RESPONSE TO PLANNING RELATED TO PLANNING APPLICATION A/266/21PL

Planning has received a number of comments from residents around the above application site. Each of these representations seem to identify common elements so I have summarised the main issues below and have prepared a response as to how we are trying to resolve these matters to make this development acceptable within planning guidelines.

SITE PLAN & VISIBILITY SPLAY
1:200

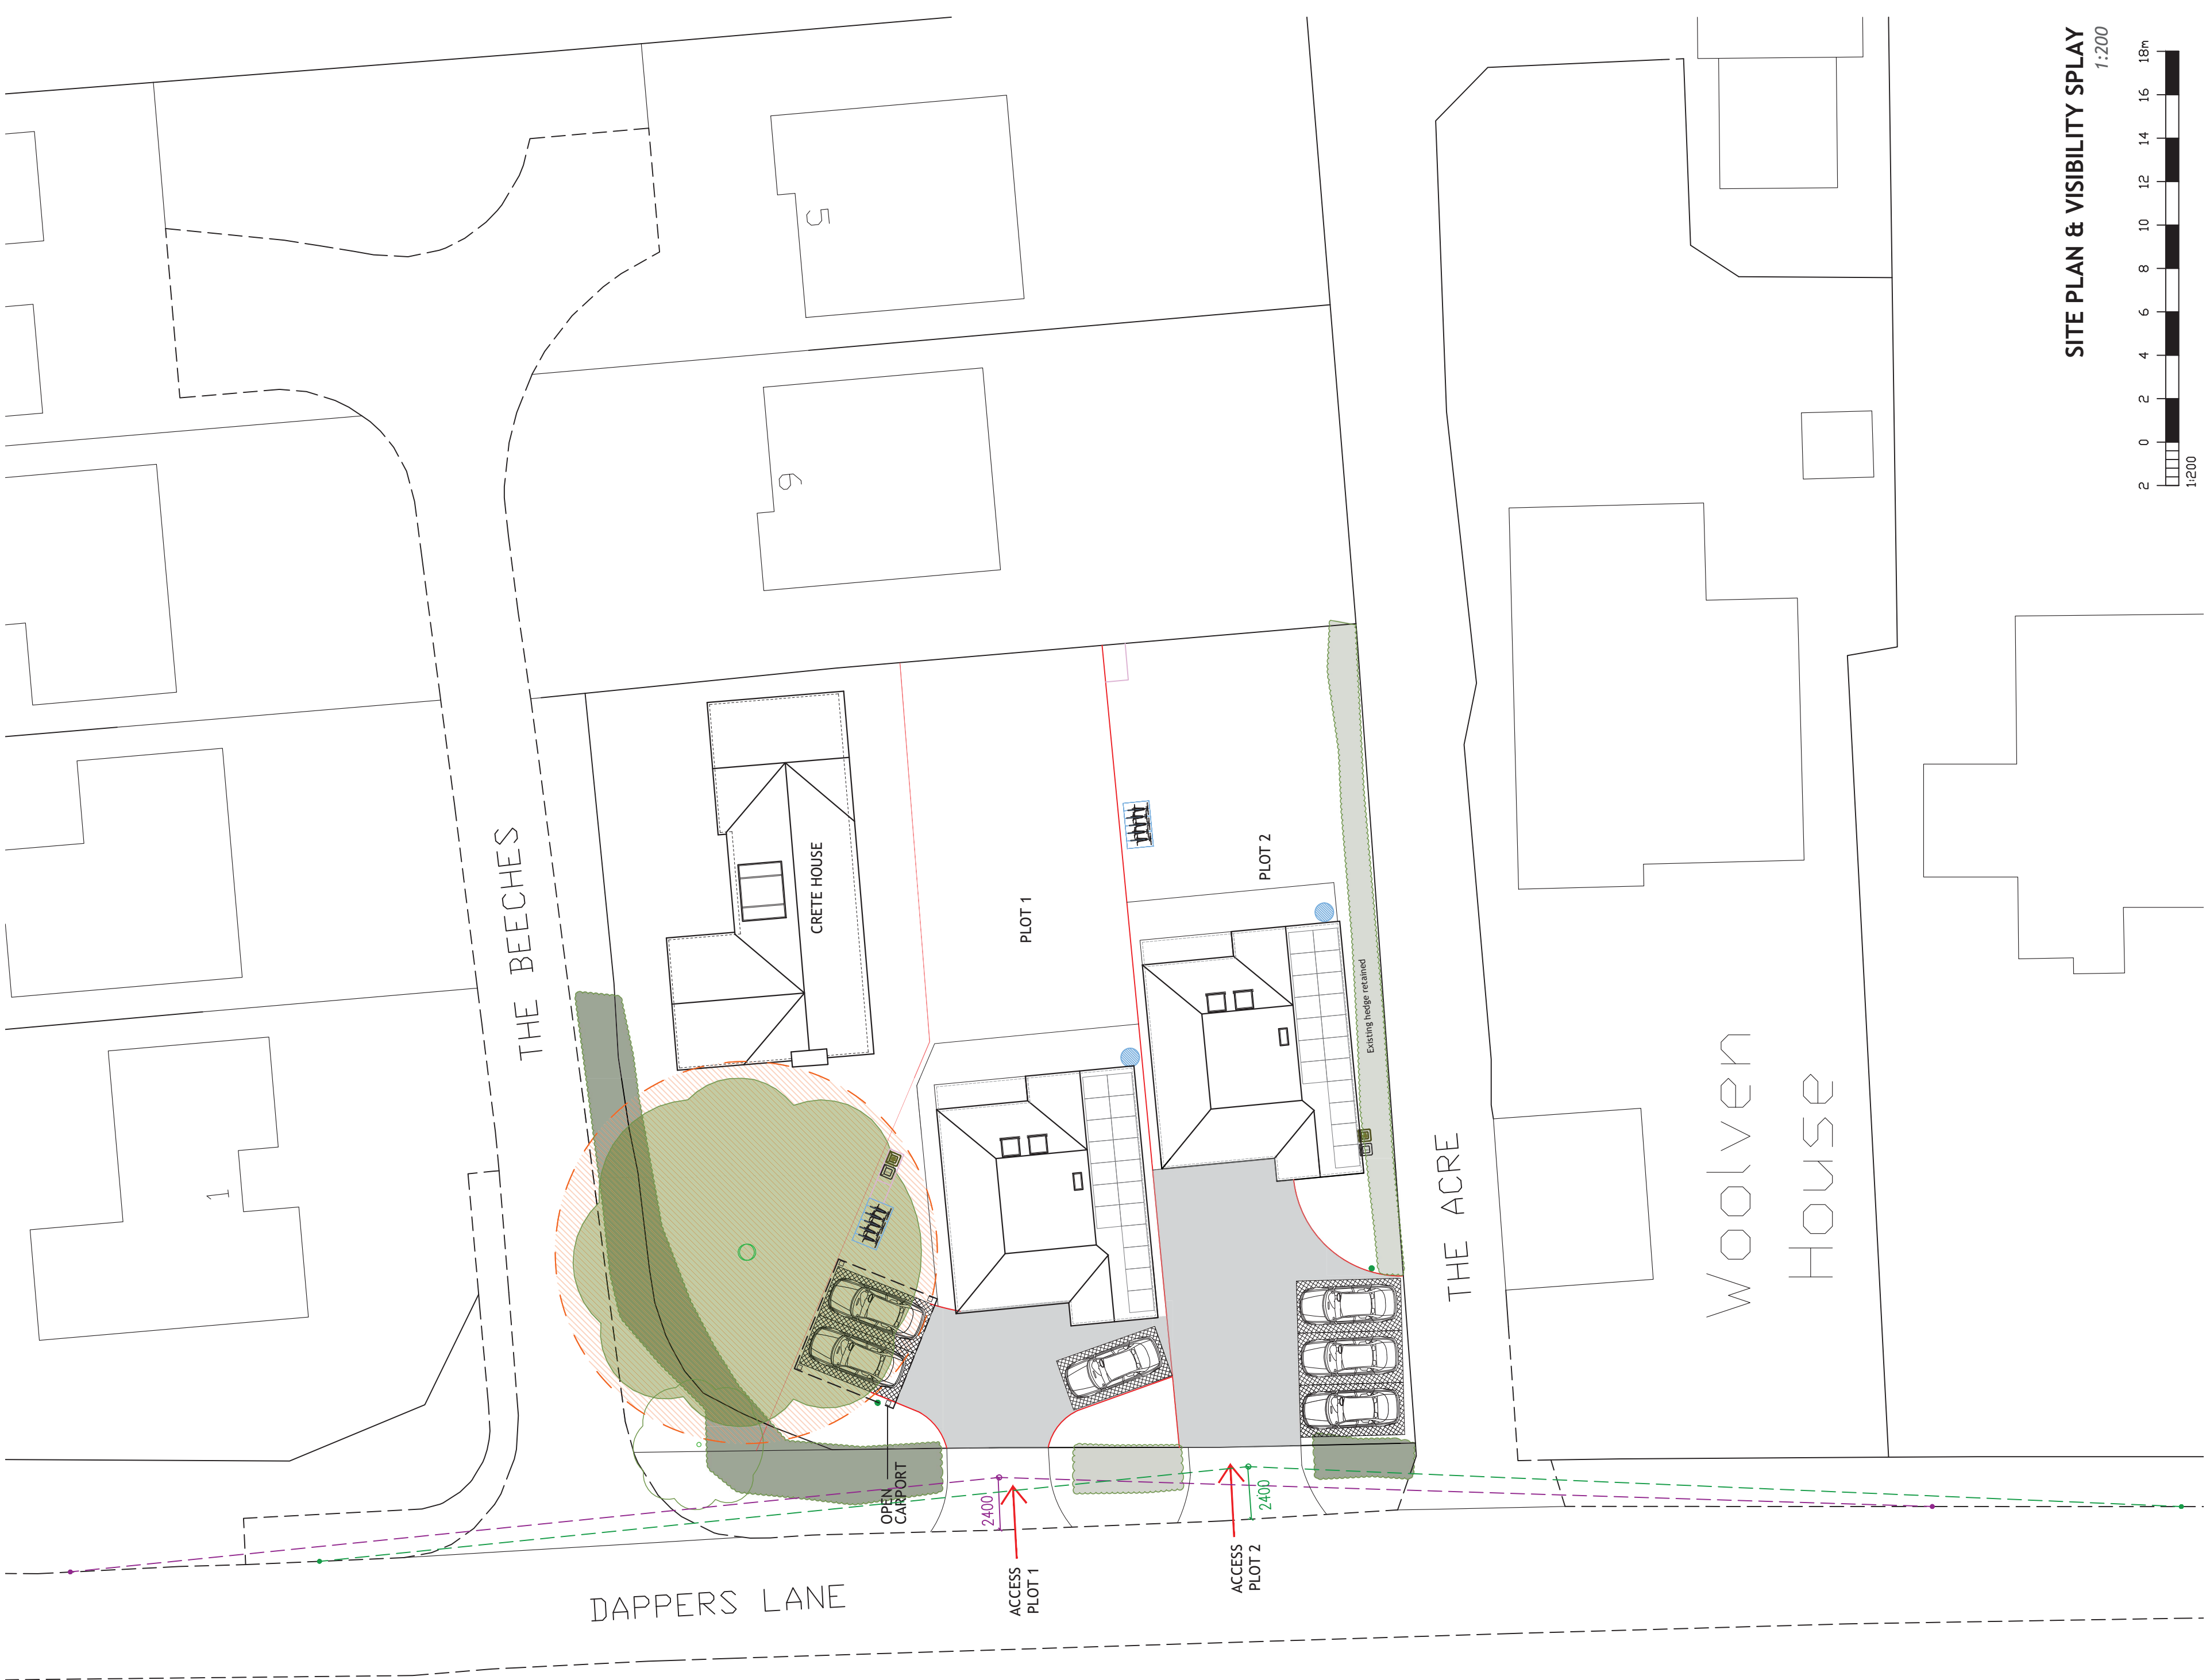
General comment #3: *Increase in traffic and concerns over highway and pedestrian safety with the addition of 2 new driveways to Dappers Lane.*

A representation letter from Highways has NO concerns on safety ground with the proposed application. They do note that the width of the proposed crossovers should be reduced to be within the range 4.5 to 6.4 m). We have reduced the crossover widths to 5m to comply with their requirements. *Please find attached the updated drawings.*

Loss of trees and hedgerows: The development proposes to remove 2 sections of the hedgerow along dapper lane identified as G2 in the arboricultural assessment. These have been assessed as low-quality trees and since the application we have reduced the size of the crossovers from 6.6 meters down to 5 meters in line with Highway recommendations. We would also propose the planting of additional native tree species inside the current hedge row on Dappers lane to thicken it out and provide a dense screen for any properties across Dappers lane. Additional tree planting will also occur on the rear boundary with No 6 The Beeches.

STREET ELEVATION (DAPPERS LANE)

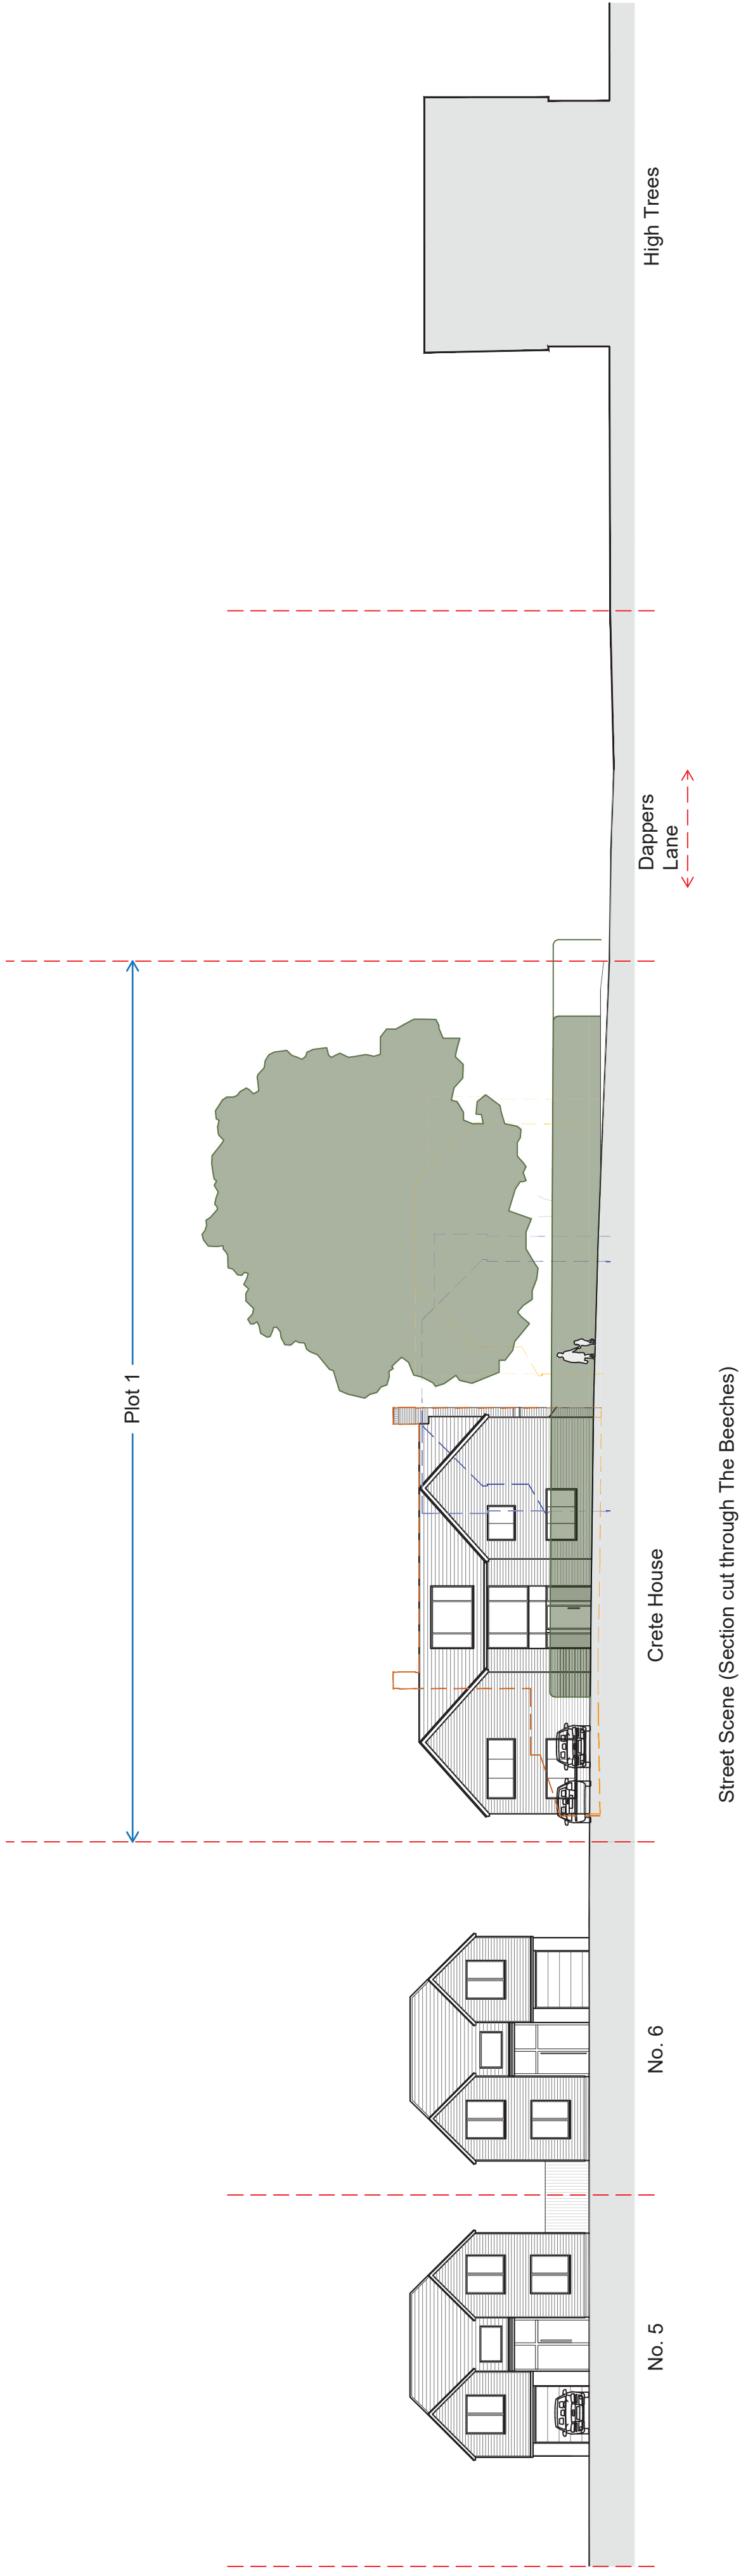
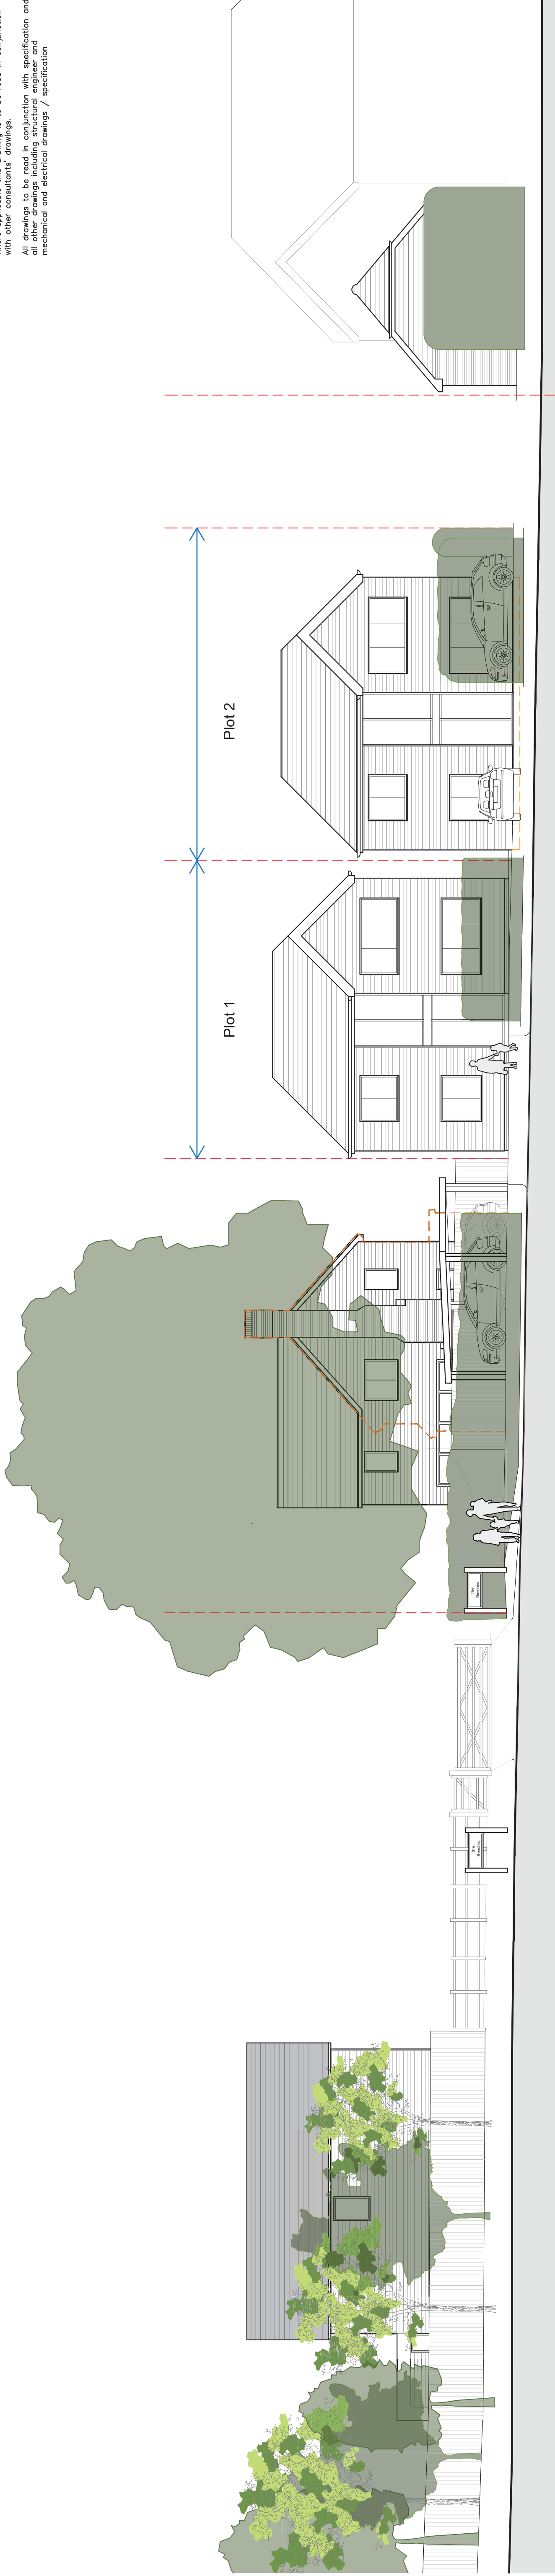
General comment #2: *2 additional houses is an over development of the area and is proposed within an area residents feel has too much development.*

The proposed development of 2 additional houses is of a reasonable scale, the houses are based on the same footprint scale and massing as number 5 and 6 the beeches. The footprint of each proposed houses is identical to Numbers 5 and 6 The Beeches and the ridge heights proposed are slightly less. (Viewed from The Beeches, the ridge heights are between 213mm – 500mm lower than number 5 & 6. When viewed from Dappers Lane the proposals sit between 1 The Beeches and Woolven House, the proposed ridge heights are between 850mm – 1650mm lower than the adjacent houses.
